WEST SUSSEX COUNTY COUNCIL CONSULTATION

TO:	Arun District Council FAO: Amber Willard
FROM:	WSCC - Highways Authority
DATE:	20 August 2021
LOCATION:	280 Chichester Road Bersted PO21 5AX
SUBJECT:	BE/127/21/OUT Outline application with some matters reserved (appearance, landscape and scale) to replace existing single storey bungalow with 2 No. 3 bed dwellings.
DATE OF SITE VISIT:	n/a
RECOMMENDATION:	Advice
S106 CONTRIBUTION TOTAL:	n/a

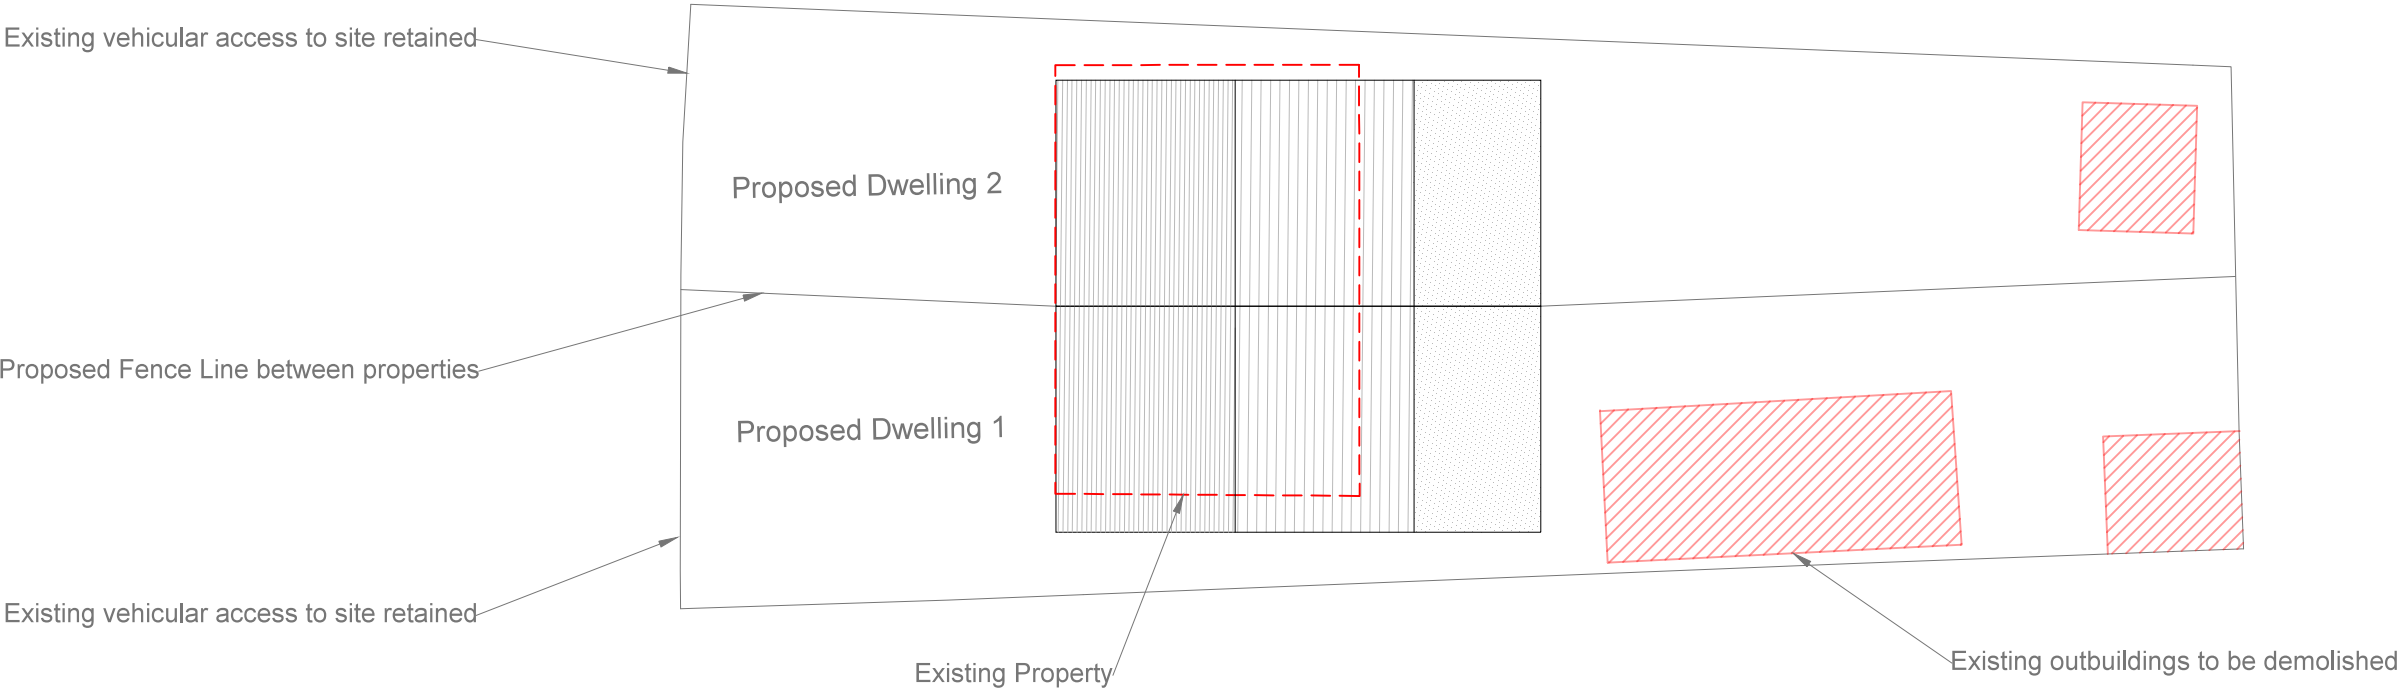
The application form indicates that two parking spaces would be provided for the proposal, but this has not been demonstrated on the proposed plans. As matters of Layout are not reserved, the LHA expects that details of parking provision are relevant at this stage of the planning process. The Arun Parking Standards expect that a minimum of 2 parking spaces per dwelling be provided for a development of this size and location. Details of parking provision can be secured by condition, although the LPA and applicant may wish to resolve such matters prior to approval.

A turn on site would be beneficial to ensure that vehicles can exit onto the public highway in forward gear. However, it is noted that neighbouring dwellings operate with a mix of ability to turn on site and with no turn on site; with no evidence of highway safety concern.

No part of the development shall be first occupied until the car parking spaces have been constructed in accordance with plans and details to be submitted to and approved in writing by the Local Planning Authority. These spaces shall thereafter be retained at all times for their designated purpose.
